Application No: EP/2/21/HH
Site Address: 27A Sea Lane East Preston BN16 1NH
Description of works: Erection of front extension to create first floor balcony, erection of rear balcony, demolition of existing conservatory with changes to external materials and wall finishes.

Thank you for your internet representation made on 24th February 2021 which has been recorded as an objection with the comments as follows:

Elevations (1:100)

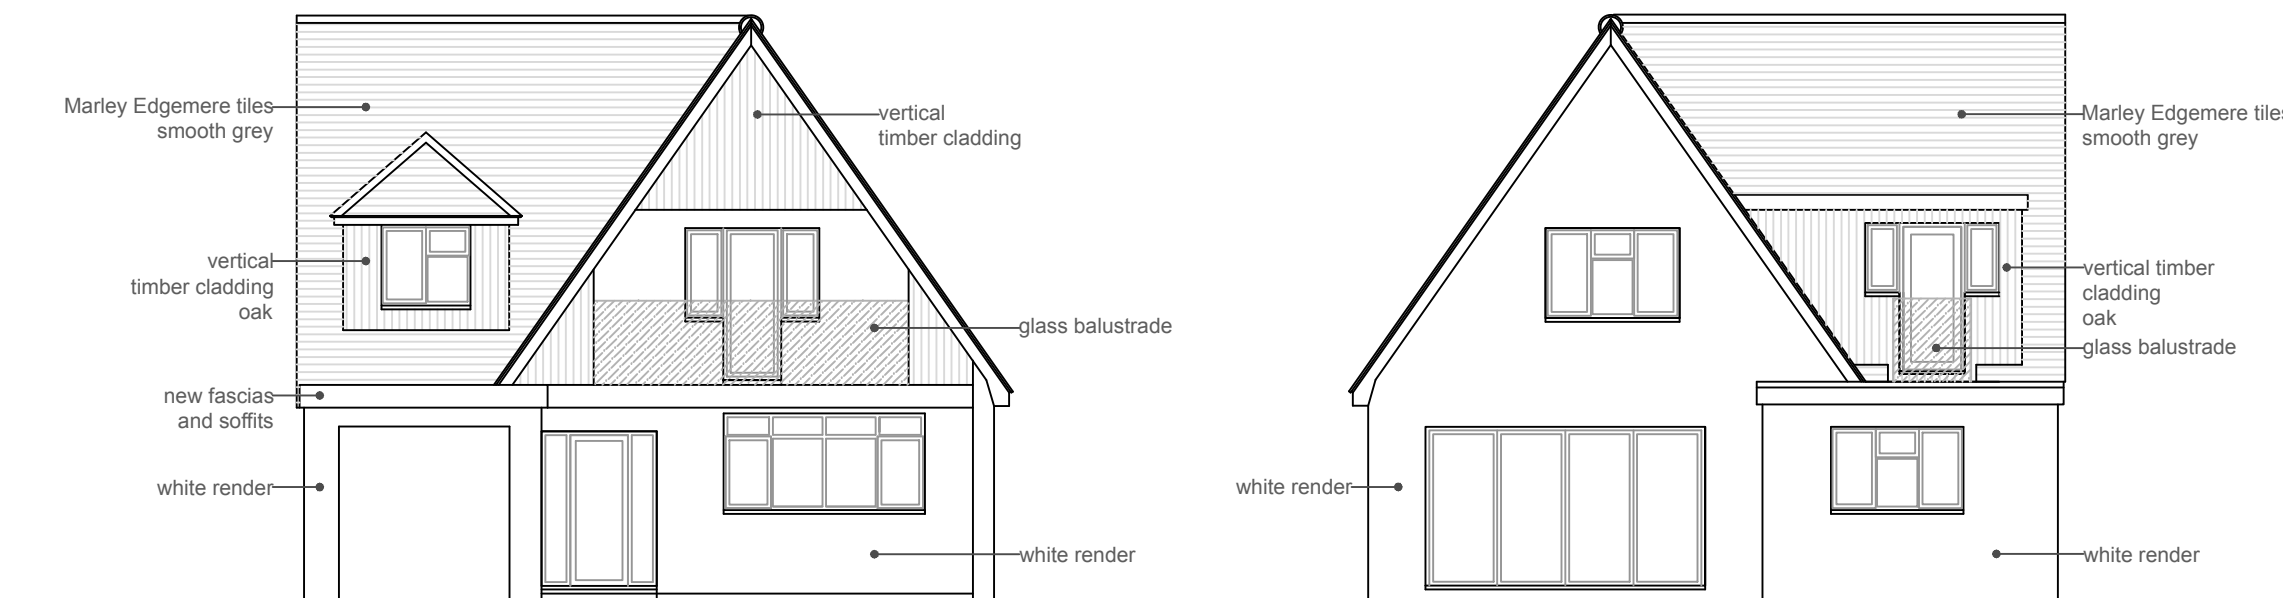
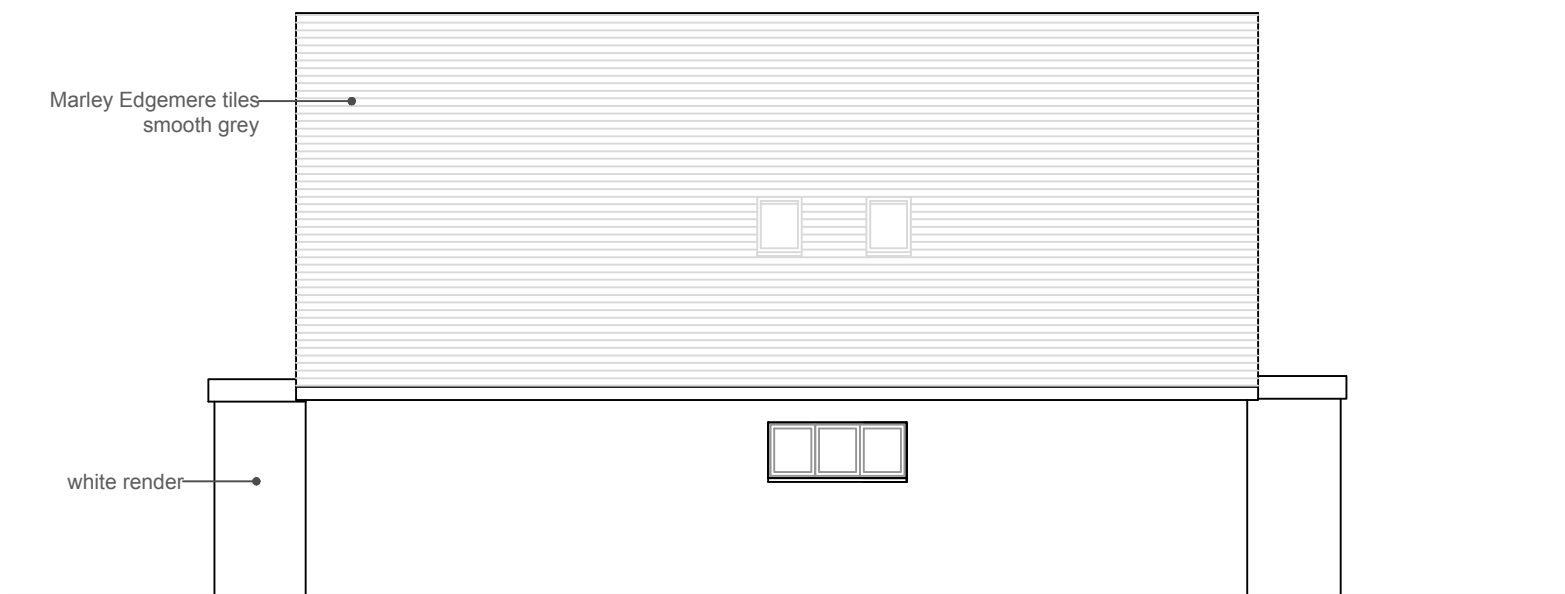
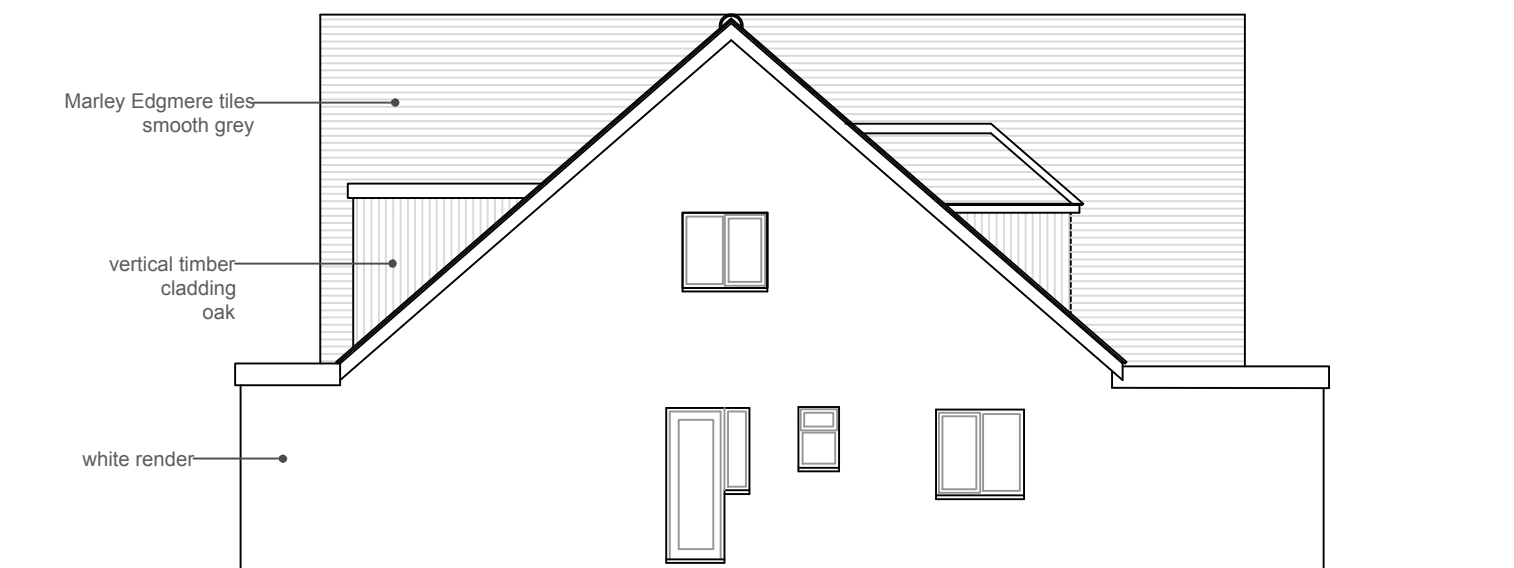
The proposal for balconies is startling and outrageous. In particular a rear balcony will overlook the properties to the rear and sides of 27A infringing on the right to privacy. A large front balcony is not in keeping with other properties in Sea Lane.

Changes to the roof, rendering, cladding are out of character with the surroundings.
